CITY OF PORTLAND, MAINE

October 14th, 2015

Project Name: Conversion of Upper Floors into Four Residential Condominiums, with Renovations and Site Improvements
Project #: #2015-157; Level III Subdivision and Site Plan
Address: 11 Brown Street, Portland
CBL: 037 1007001
Applicant: LK Exchange, LLC
Planner: Jean Fraser

PROPOSED SITE PLAN
SCALE: 1/8" = 1'-0"

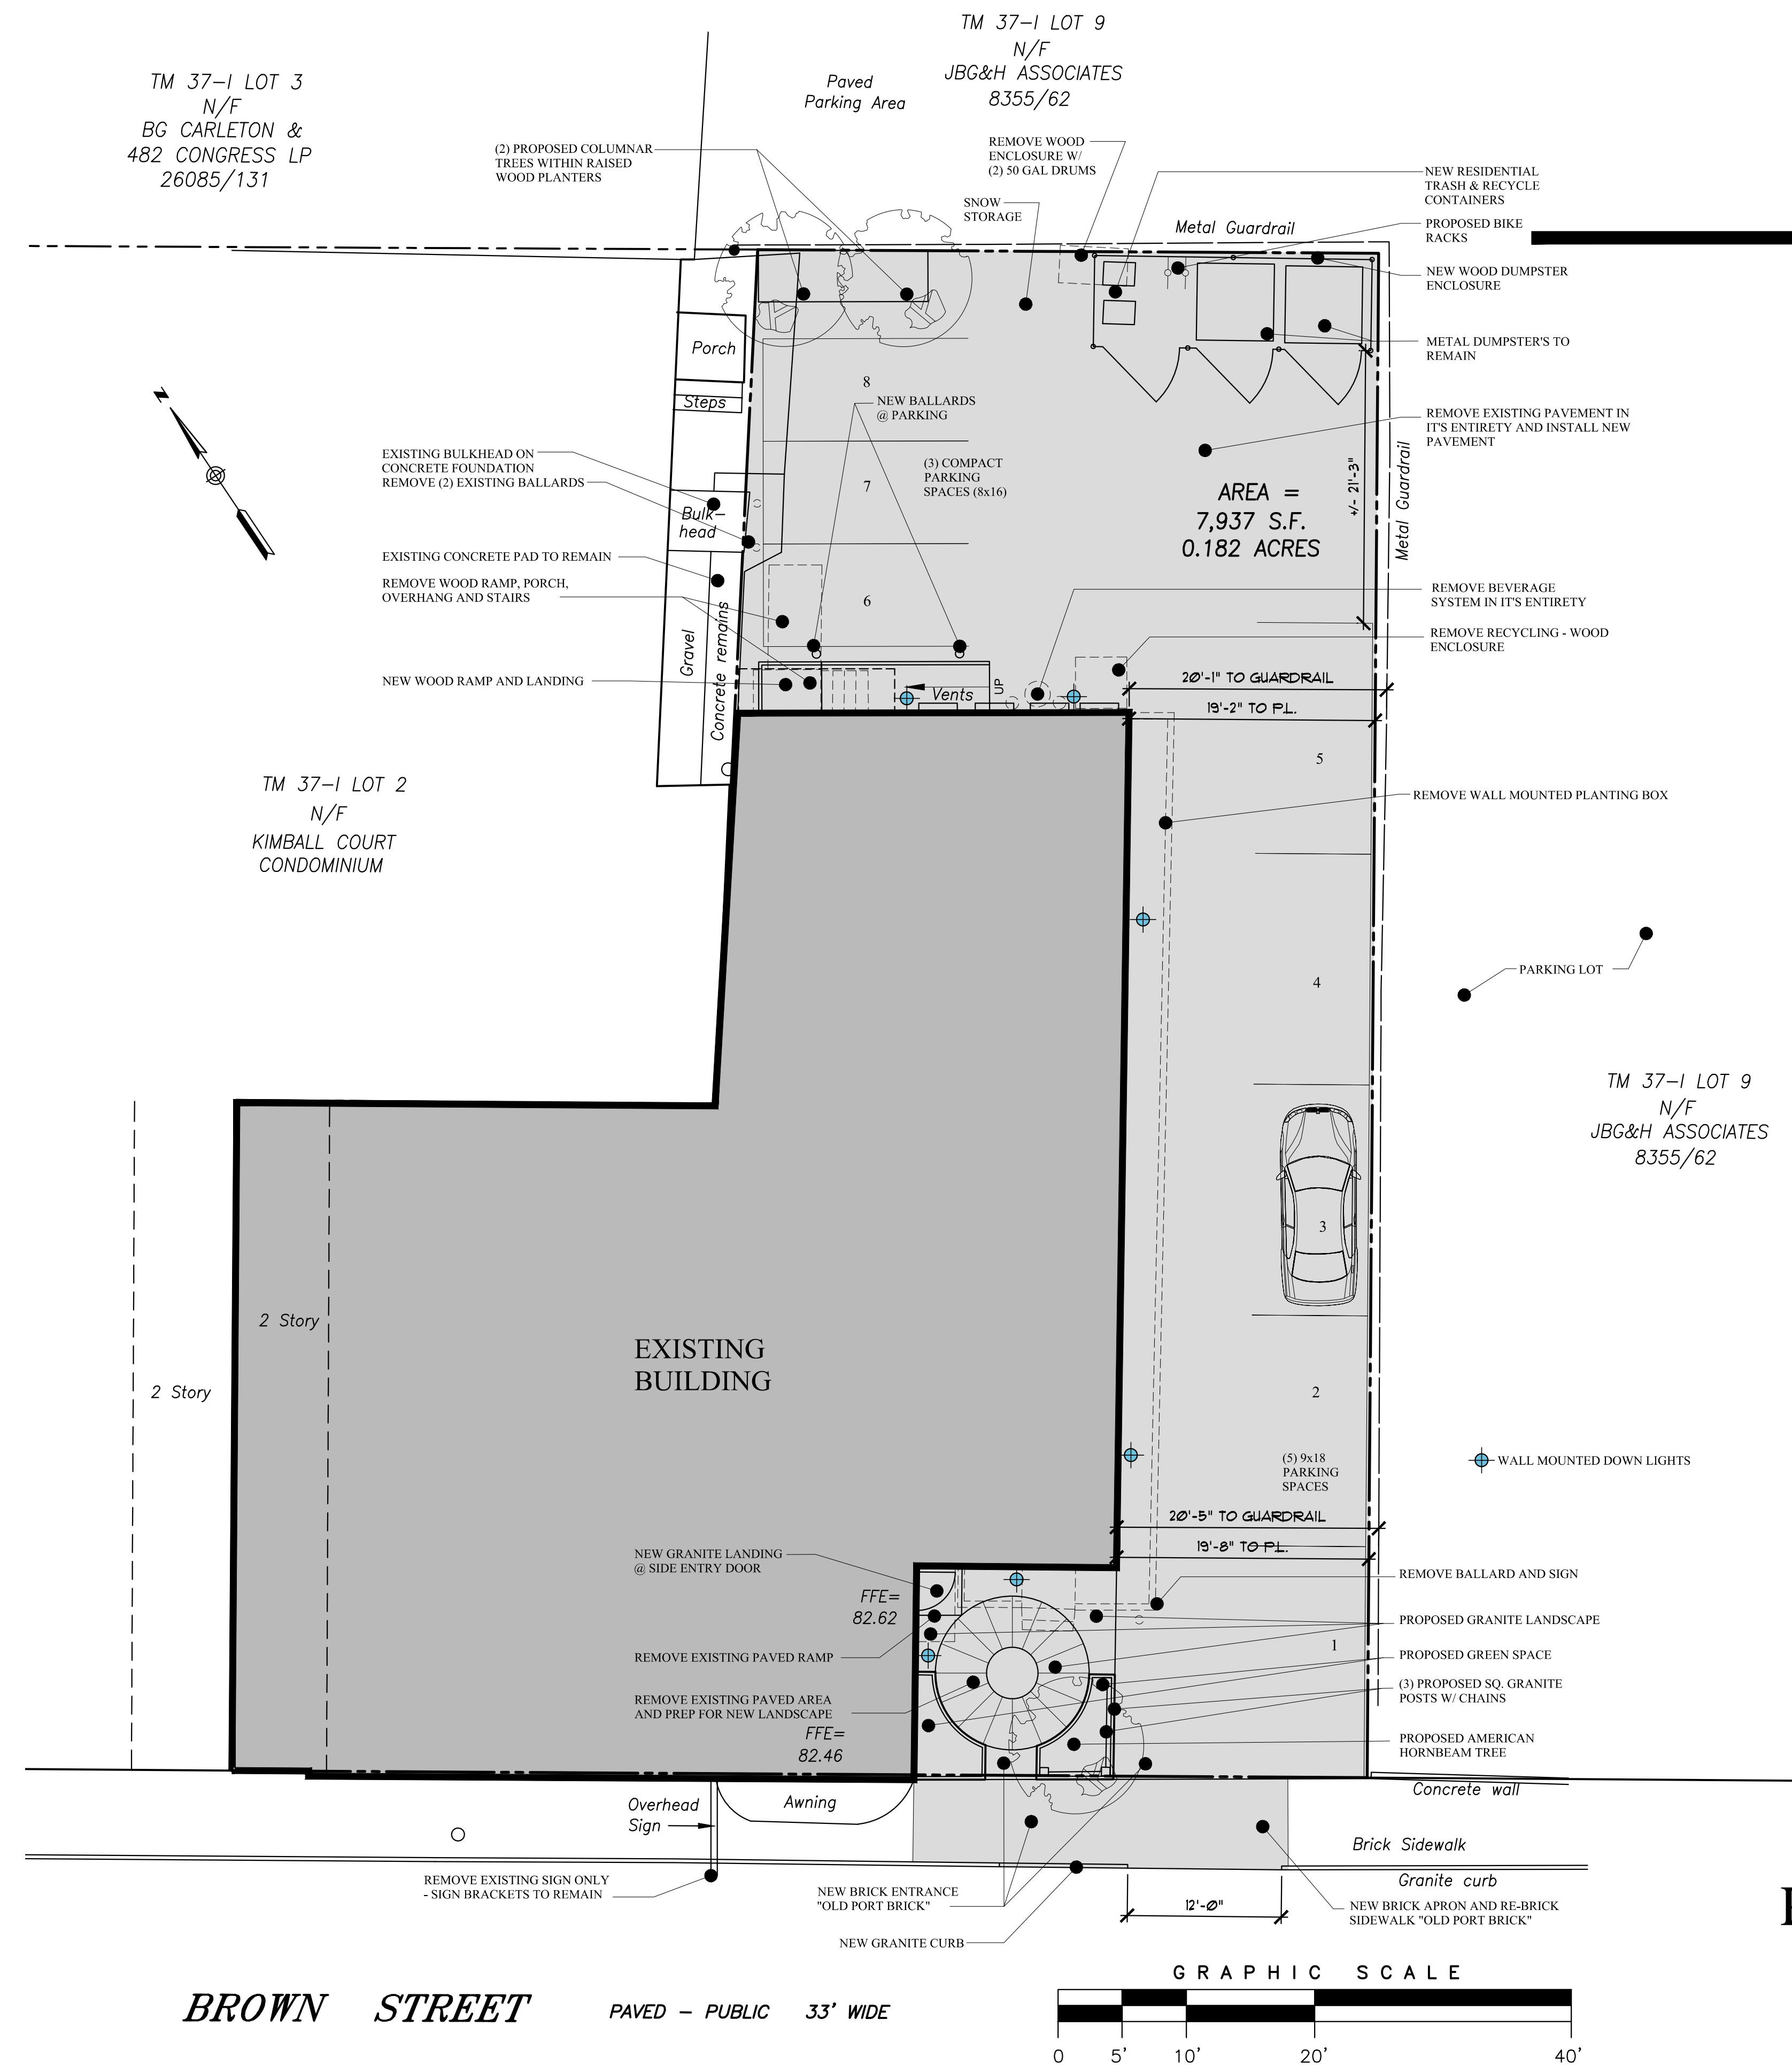
- i. That the applicant shall submit a revised landscape detail (showing materials and dimensions) for (a) the dumpster enclosure and (b) the area near the ROW between the building and the south property line to address the 10.7.2015 comments of the City Arborist, incorporate the bike rack, and place a bollard at the ROW line in front of the first parking space, for review and approval by the Planning Authority and Historic Preservation Program Manager prior to the issuance of a building permit; and

- ii. That the applicant shall submit a plan showing the design and location of the bicycle racks, meeting the specifications in the City's technical manual and located in two locations (one rack for 2 bicycles in the area near the ROW, and one in the rear yard enclosure), for review and approval by the Planning Authority and Historic Preservation Program Manager prior to the issuance of a building permit; and

- iii. That the applicant shall submit a revised on-street parking layout that takes account of the revised curb cut and addresses the suggestion for a commercial loading area (possibly south of the curb cut), for further discussion and agreement with the Planning Authority and the City Parking Department. It should be noted that any changes to on-street parking will require City Council action prior to the issuance of a Certificate of Occupancy, and the applicant would be required to assist in preparing council meeting materials; and

Street-trees: The project proposes the planting of one 'street tree' near the Brown Street entrance and two 'parking lot' trees in the parking lot area. The one 'street-tree' near Brown Street meets the landscape standard, the two trees in the parking lot meet the condition of being within 10' of the property line but not near the City 'right of way' and can not be considered as substitutes for street trees.

Parking Lot Landscape - Due to site constraints for traffic circulation and parking the existing landscape planting is slated for removal. Ideally some type of landscape should be considered along the building / pavement edge. This could be in the form of a small planter with vines or something hardy like Comptonia (Sweetfern) or ornamental grasses if space allows. Efforts to secure the guardrail improvement between the two lots should be condition as the existing separation is in poor if not unsightly condition. Improved guardrail should have rails on both sides to help prevent damage to vehicles and to improve the overall view of the parking lot and help define circulation. This could be 'Core-ten' steel on wood post or wood post with wood rails. (The current guardrail does not appear to be functioning well from the image attached.)

Plaza Landscape - the proposed plaza entrance improvements are one of the projects bright spots in regards to landscape improvements. Recommendations would include having a slightly raised planting bed to reduce winter de-icing salt damage to plants and to help create separation for the walking surface to plant space protection. The raised edge could be concrete formed, granite curbing, wooden or steel edging. Landscape planting should 'wrap around' towards the building frontage facing the street to help define the circulation along with adding a greener street look. Concept wise the design adds interest to the current conditions. Unknown if the proposed plaza and residential entrance meets ADA standards or if a slight ramp is needed?

Dumpster enclosure - This project site has a very visible dumpster location due to the exposed adjacent parkinglot from Free Street. Adequate dumpster screening meeting standards would be a condition.

- * The compact parking spaces are slightly larger than City Standards. I support a waiver for larger spaces.
- * The general parking lot and access will not be significantly different from existing conditions (although the width of the entry roadway will increase with the removal of the raised planting bed). Vehicles parking along the guard rail will have the ability to turnaround in the rear of the property. I would also note that given Brown Street traffic conditions, I find backing maneuvers to be acceptable. I find parking and circulation to be acceptable.

- * The applicant should consider treatment that prevents vehicles parked in space #1 from encroaching onto the sidewalk.
- * The applicant is proposing narrowing of the curb cut, which I find to be acceptable. This change will increase the length of curb side parking and during discussions with the applicant a commercial loading regulation was suggested. I support this change, but would like to discuss this with the City Parking Department. I would also note that changes to on-street parking will require City Council action and the applicant would be required to assist in preparing council meeting materials.

- * The bicycle racks are located in least accessible location on the site. The applicant should consider other more accessible and visible locations.
